DECISION DELEGATED TO HEAD OF PLANNING

Application No: H09-0895-22 **Applicant:** Holbeach United Community Sports Academy

Proposal: Details of demarcation of individual standard car parking bays. (Condition 3 of H09-1184-21)

Location: Holbeach United Community Sports Academy Penny Hill Road Holbeach

ONSITE PARKING
ARRANGEMENTS

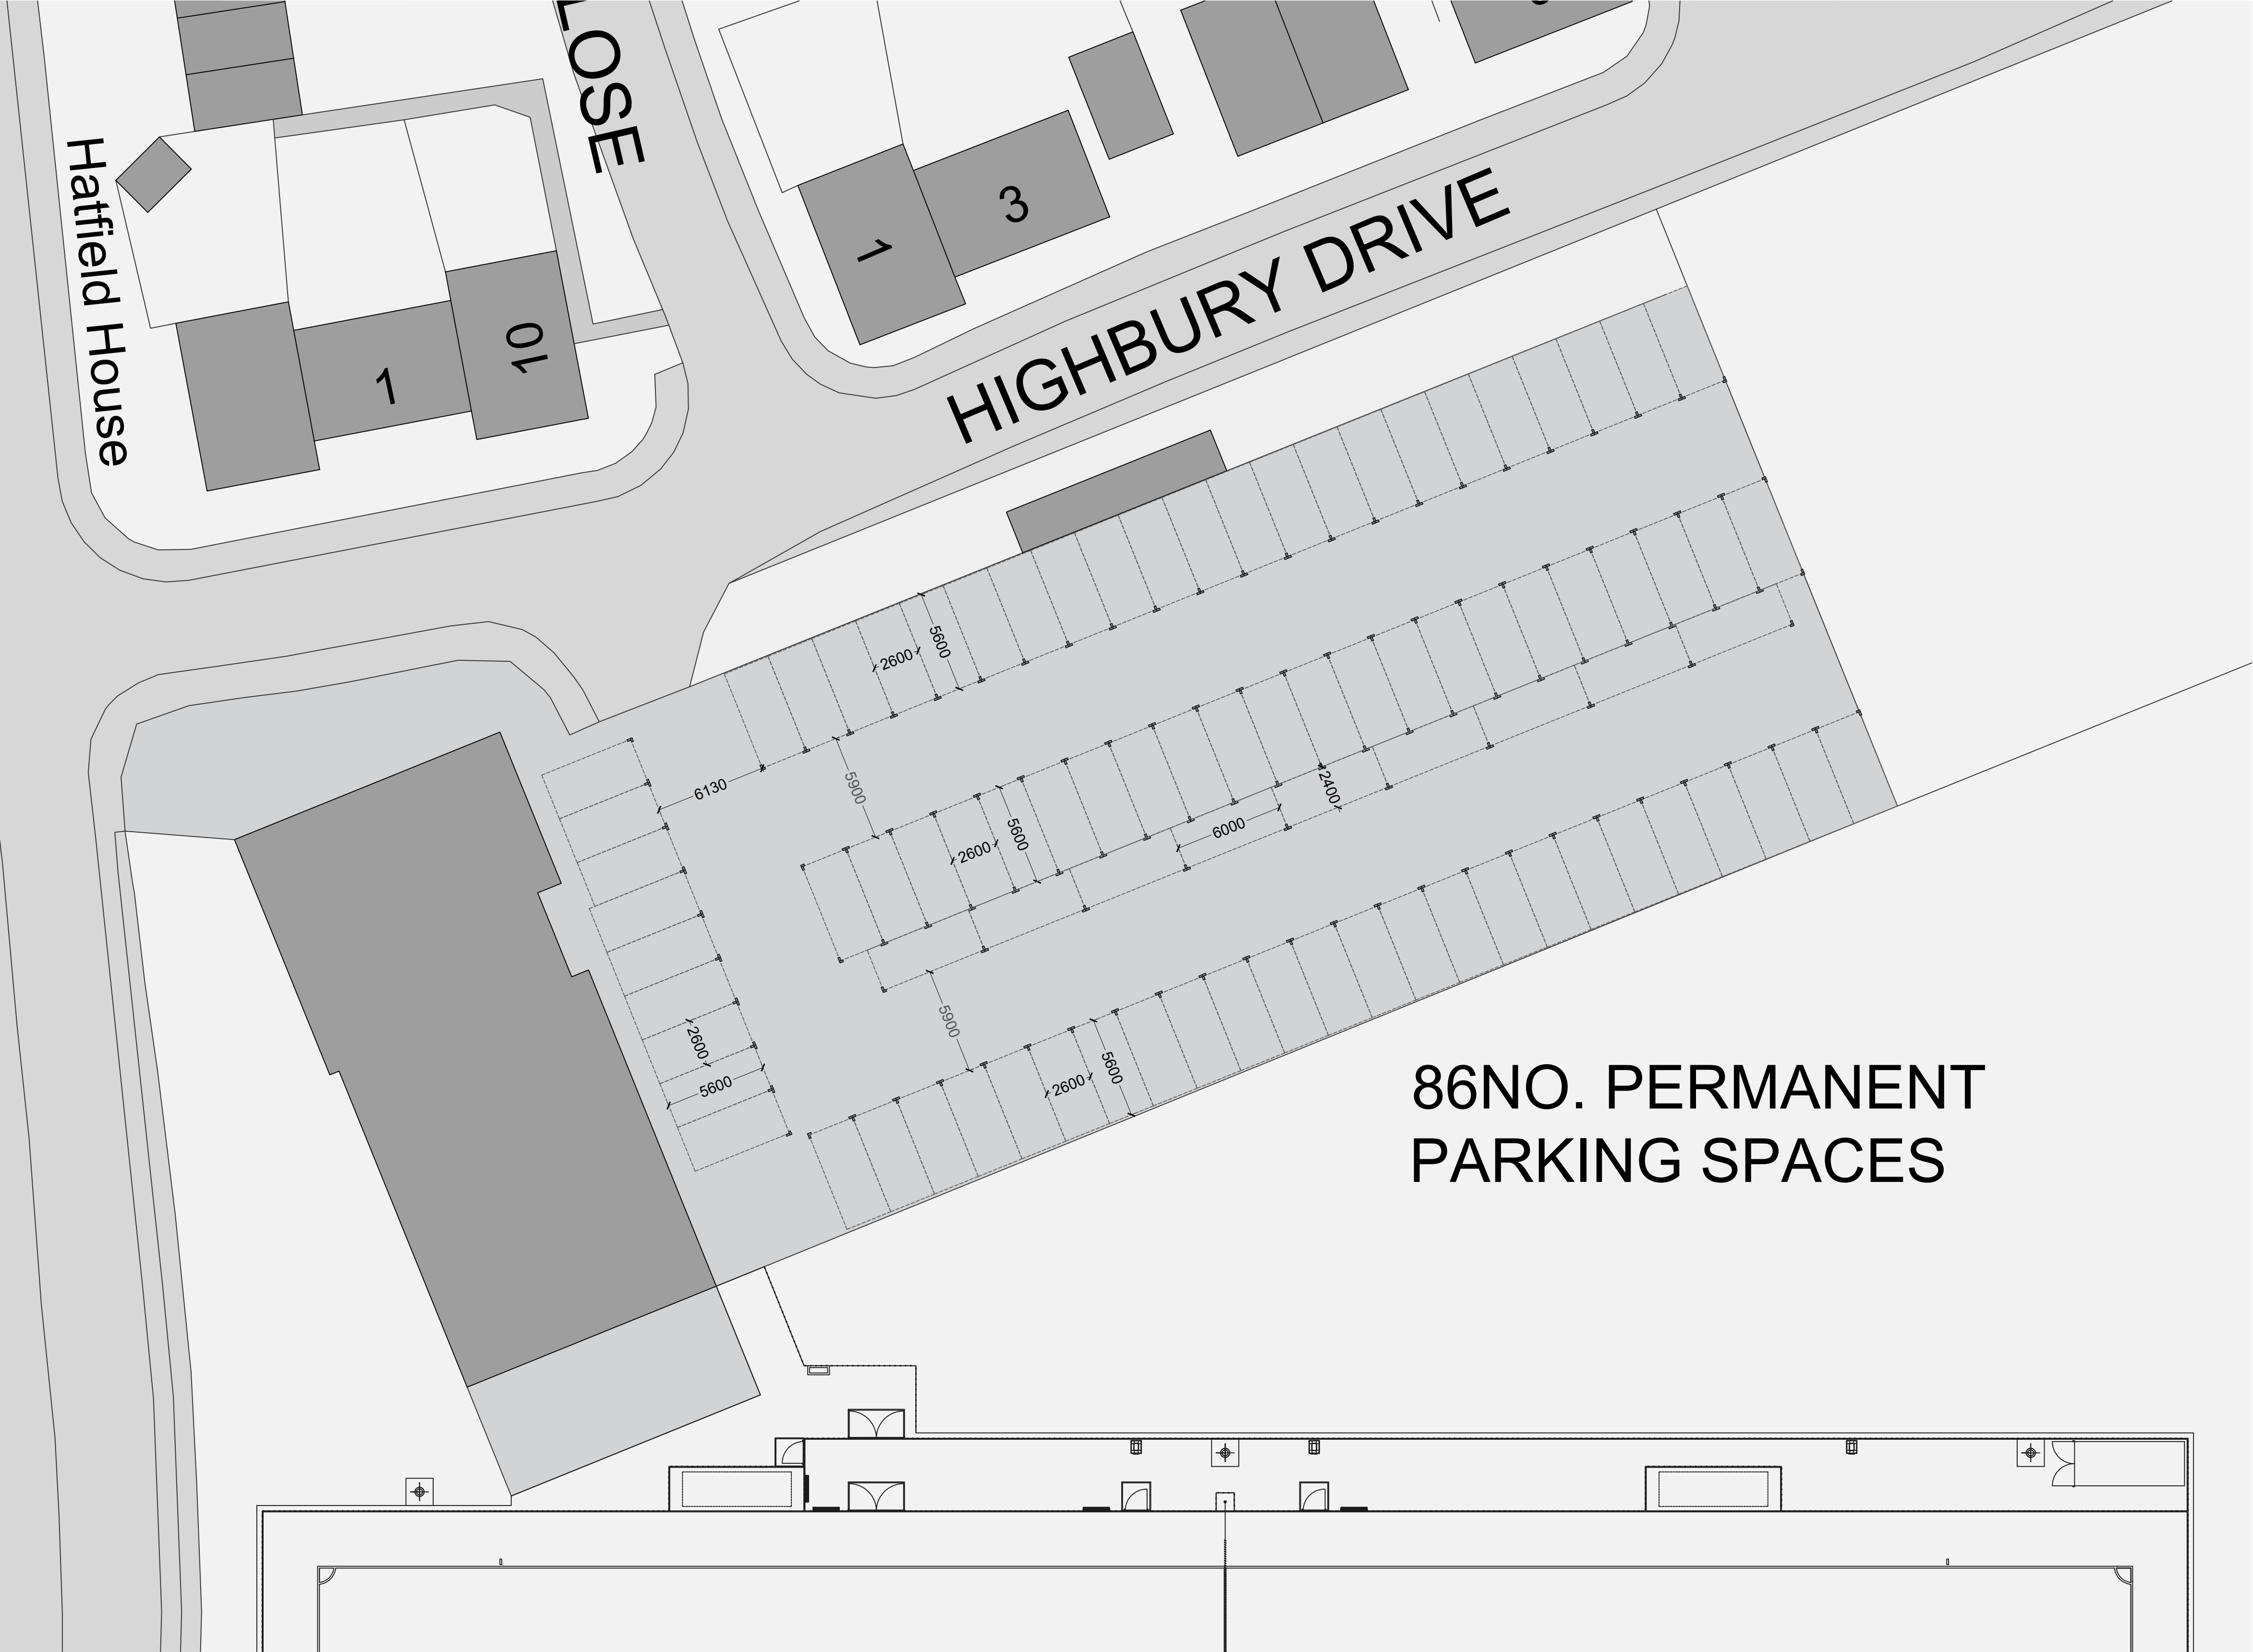
The submitted 'Onsite Parking Arrangements' plan indicates a total of 86 permanent parking spaces, to be demarcated by brick paving blocks.

The Highway Authority's comments above are self-explanatory. On the basis of their no objection response, it is considered that the proposed measures of demarcation are acceptable.

Taking the above into account, it is considered that Condition 3 of H09-1184-21 can be discharged.
